From: Simon Davis <Simon.Davis@arun.gov.uk>
Sent: 15 July 2020 10:50
To: Planning.Responses <Planning.Responses@arun.gov.uk>
Subject: FW: BN/39/20 - Tars Farm, Church Lane, Barnham

Further WSCC Highways comment re visibility

From: Stephen Garrard [REDACTED]
Sent: 15 July 2020 09:51
To: McCauley, Lindsay [REDACTED] Simon Davis <Simon.Davis@arun.gov.uk>
Subject: BN/39/20 - Tars Farm, Church Lane, Barnham

Drawing No.	Rev
NJC-001	-

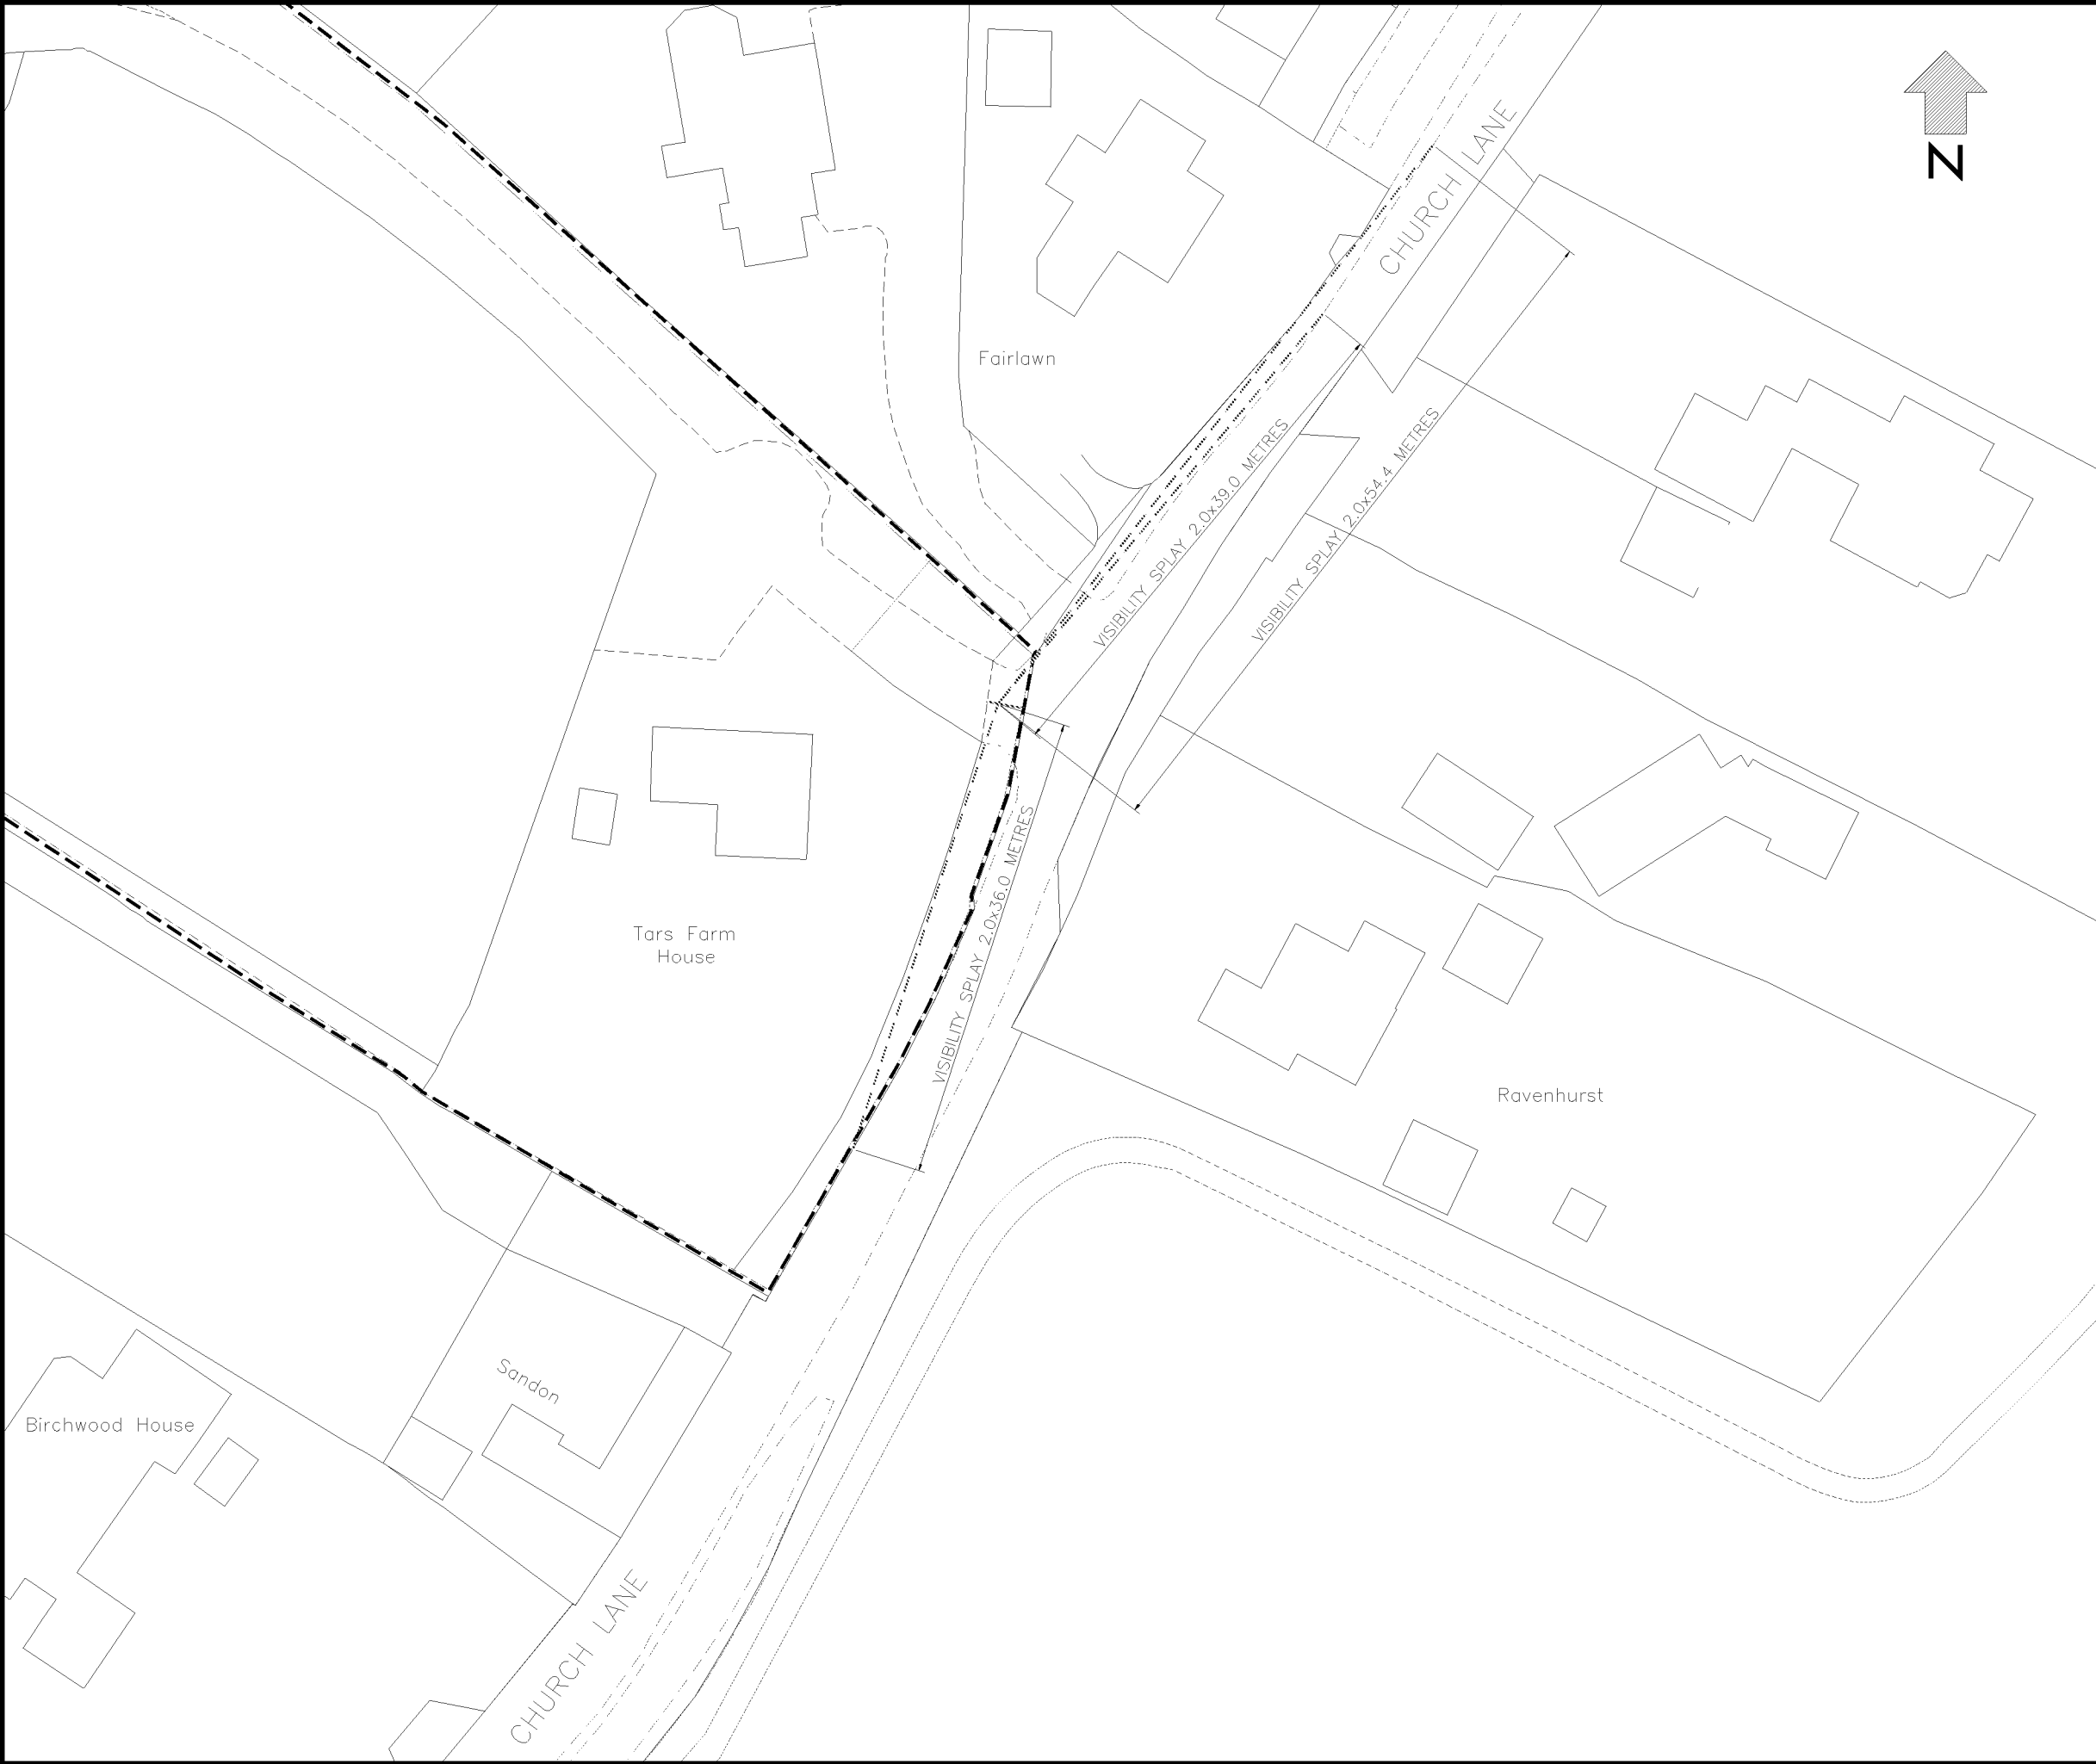
The LHA request the applicant provides maximum achievable visibility splays with a set back distance of 2 & 2.4 metres.
